## Application for Removal or Variation of a Condition following Grant of Planning Permission or Listed Building Consent

Alteration, extension, refurbishment and change of use of existing commercial buildings to create a Remote Internal Temporary Storage Facility

55936/APP/2021/2751

We are seeking the substitution and approval of revised GA Plan and Elevation drawings as follows:

Planning revisions 201033 - A and 100123 - B

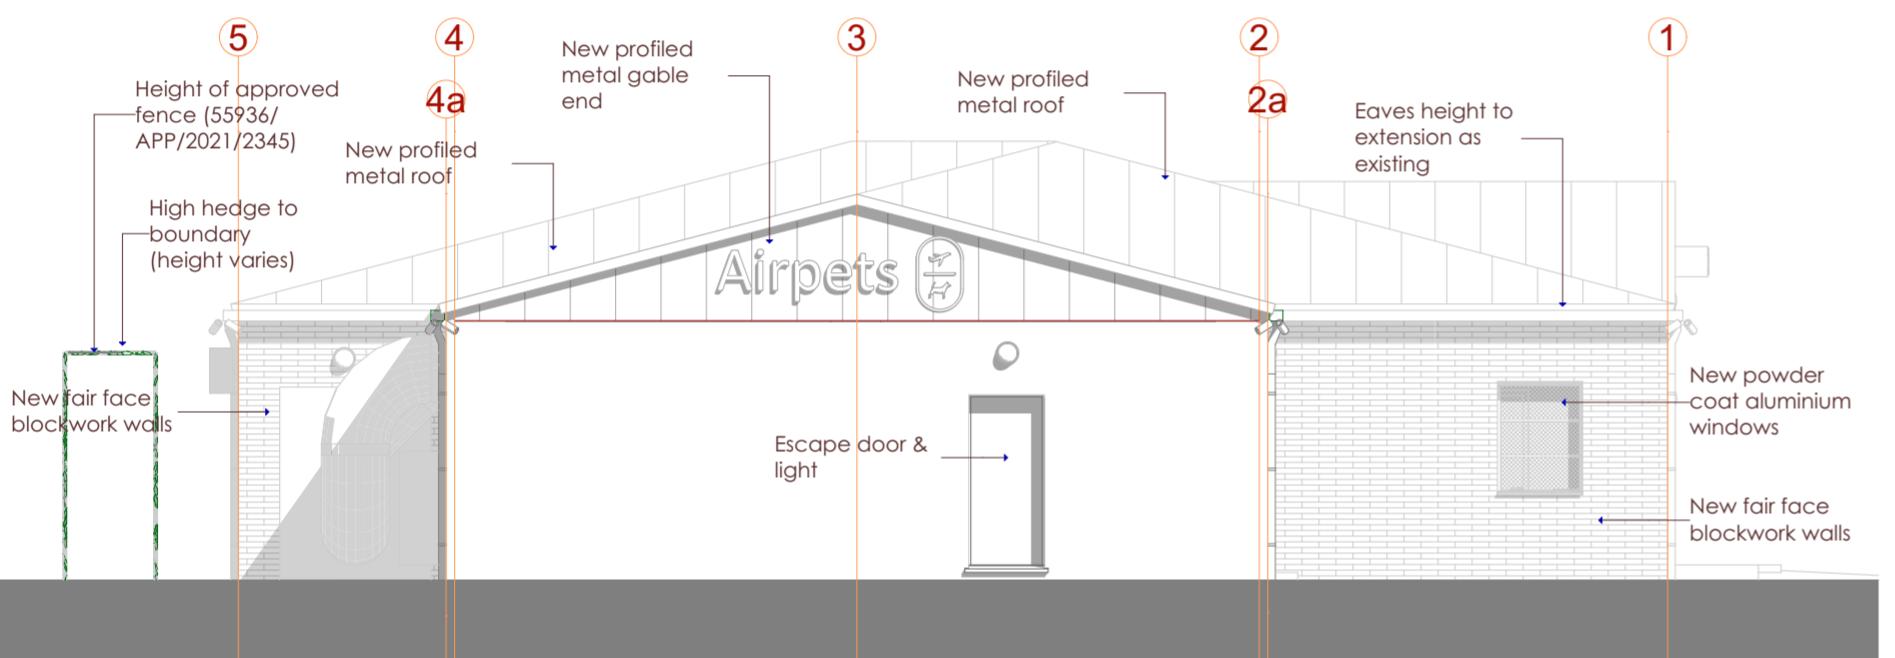
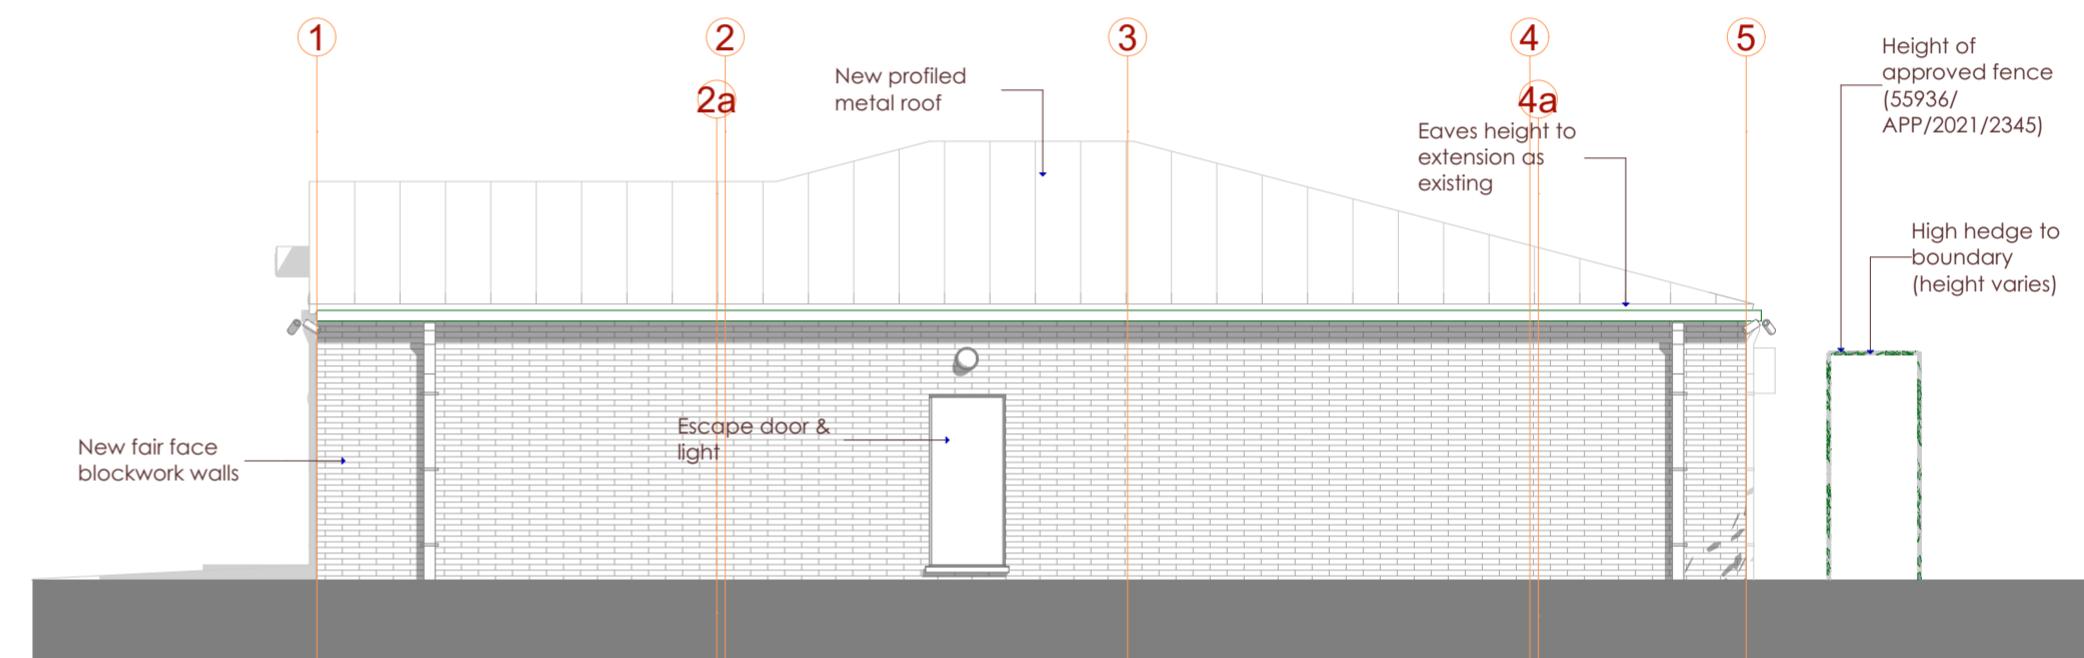
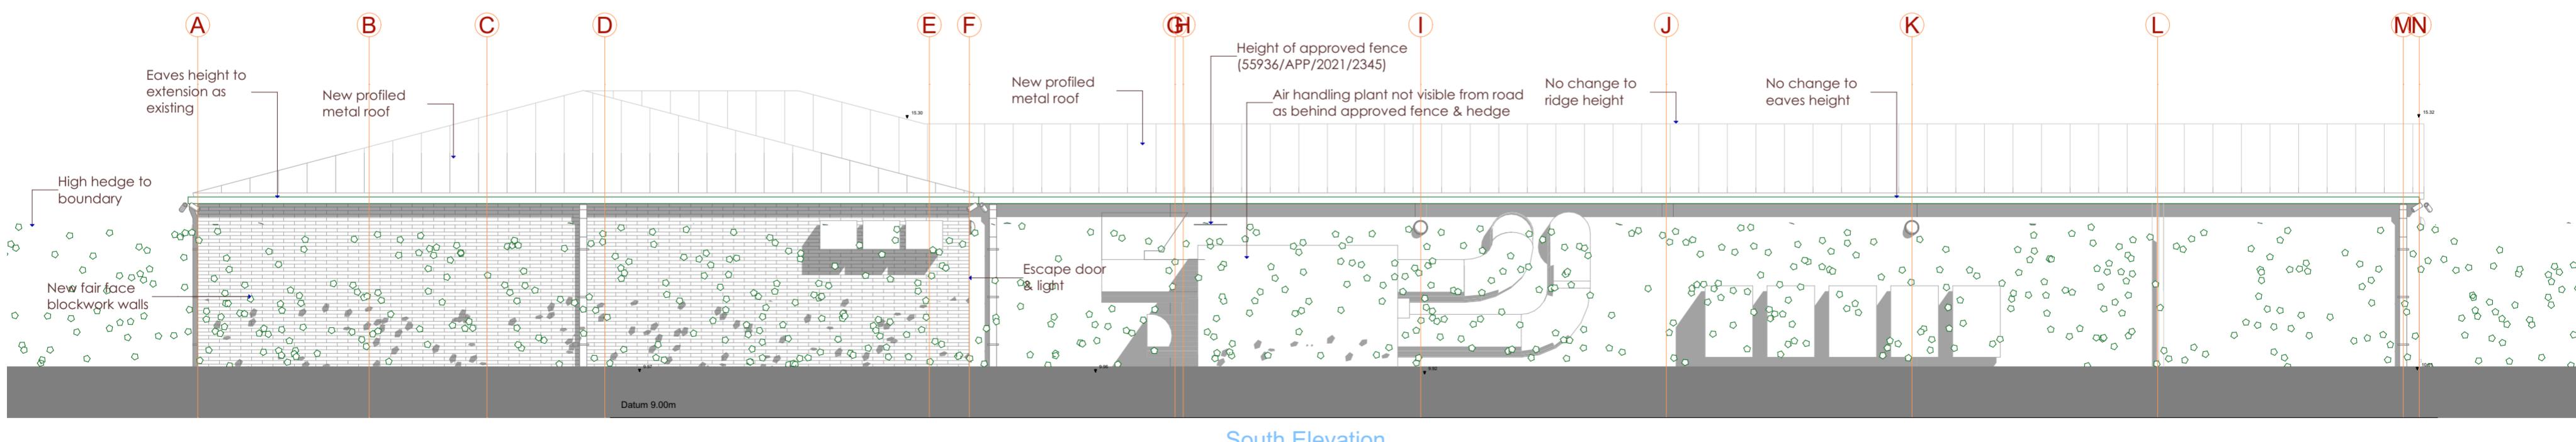
Simplified roof form to extension (with slightly higher ridge to extension in order to avoid flat section of roof)

Removal of windows to south elevation (omitted on road side for security)

Additional plant (improved climate control for animals & staff - APHA spec)

Added glazing bars to windows

Defined external access / egress pathways.

Added glass canopy over front door.

Proposed Elevations - 506/P/1.4 to be updated / replaced with 506/P/1.4 Rev B
